Reference No:	2023/62/92628/W
Site Address:	59-61, Moorbottom Road, Thornton Lodge, Huddersfield, HD1 3JT
Description:	Erection of front and rear dormers
Recommending Officer:	Laura Yeadon

HOUSEHOLDER DELEGATED REPORT

Application Number	2023/92628
Location	59-61, Moorbottom Road, Thornton Lodge, Huddersfield, HD1 3JT
Proposal	Erection of front and rear dormers
Publicity end date	19 th October 2023
Number of representations received	None
Kirklees Local Plan Allocation/Designation	Unallocated land without notation on the Kirklees Local Plan
Extension to Time (EoT)	Requested to 17.1.2024
Recommendation	Conditional Full Permission

Proposed Elevations

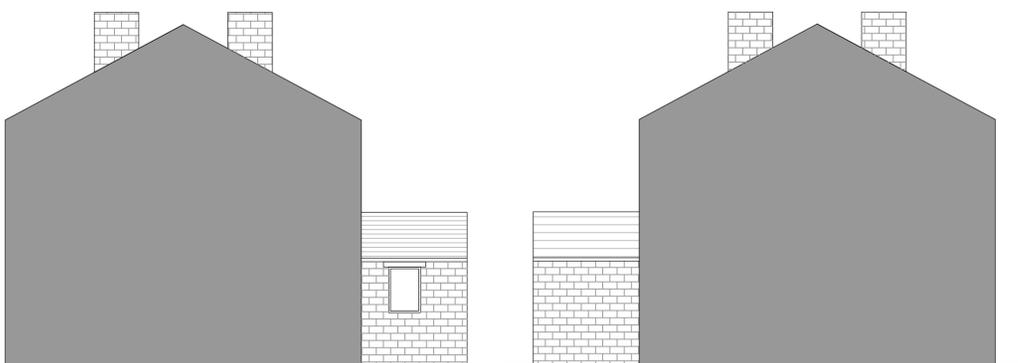
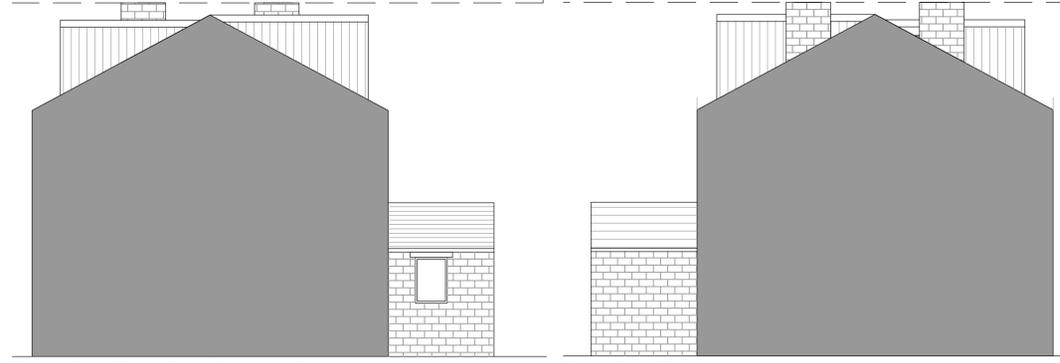
YES / NO	SUMMARY
Negotiations/Amendments during course of application	Yes	It was requested that the dormer extension to the front elevation of the property was reduced in width to improve the impact on visual amenity – amended plans were submitted on 15 th November 2023 and form the basis of this assessment
Parish/Town Council comments sought	No	N/A
Planning History	No	None
Consultations required	No	None

The front dormer extension has been reduced in size from its original submission and a reduction of 1 metre in width has been submitted. The total width of this dormer would now be a width of 2.6 metres being a total height of 1.5 metres set in from the shared boundary with No. 55 by 1.8 metres and in from the shared boundary with No. 63 by 2.9 metres. The dormer would be set up from the gutter line by 0.9 metres and set down from the roof ridge by 0.2 metres. It is proposed that the dormer shall be constructed from cladding.

The proposed rear dormer would be a width of 6.1 metres being a total height of 2.4 metres set in from the shared boundary with No. 57 by 0.8 metres and in from the shared boundary with No. 63 by 0.4 metres. The dormer would be set up from the eaves by 0.3 metres and would lie flush with the roof ridge.

Dormer extensions should:	<u>Yes - COMPLY</u>	<u>No - JUSTIFY</u>
relate to the appearance of the house and existing roof	Yes – both dormers would sit within the confines of the existing roof slope	
be designed in style and materials similar to the appearance of the existing house and roof	No – finishing materials would be cladding	Cladding is a typical material for dormer extensions – colour can be conditioned to be dark grey to match colour of the existing roof
not dominate the roof or project above the ridge of the house	Yes – following amendments	
be set below the ridgeline of the existing roof and within the roof plane	Yes – front elevation dormer would comply	No – rear elevation dormer would not comply as would be flush with the existing roof line – likely a PD fall back in place in this case

3. The hereby approved dormer windows shall be finished in a dark grey cladding. The materials of construction and colour finish shall thereafter be retained.
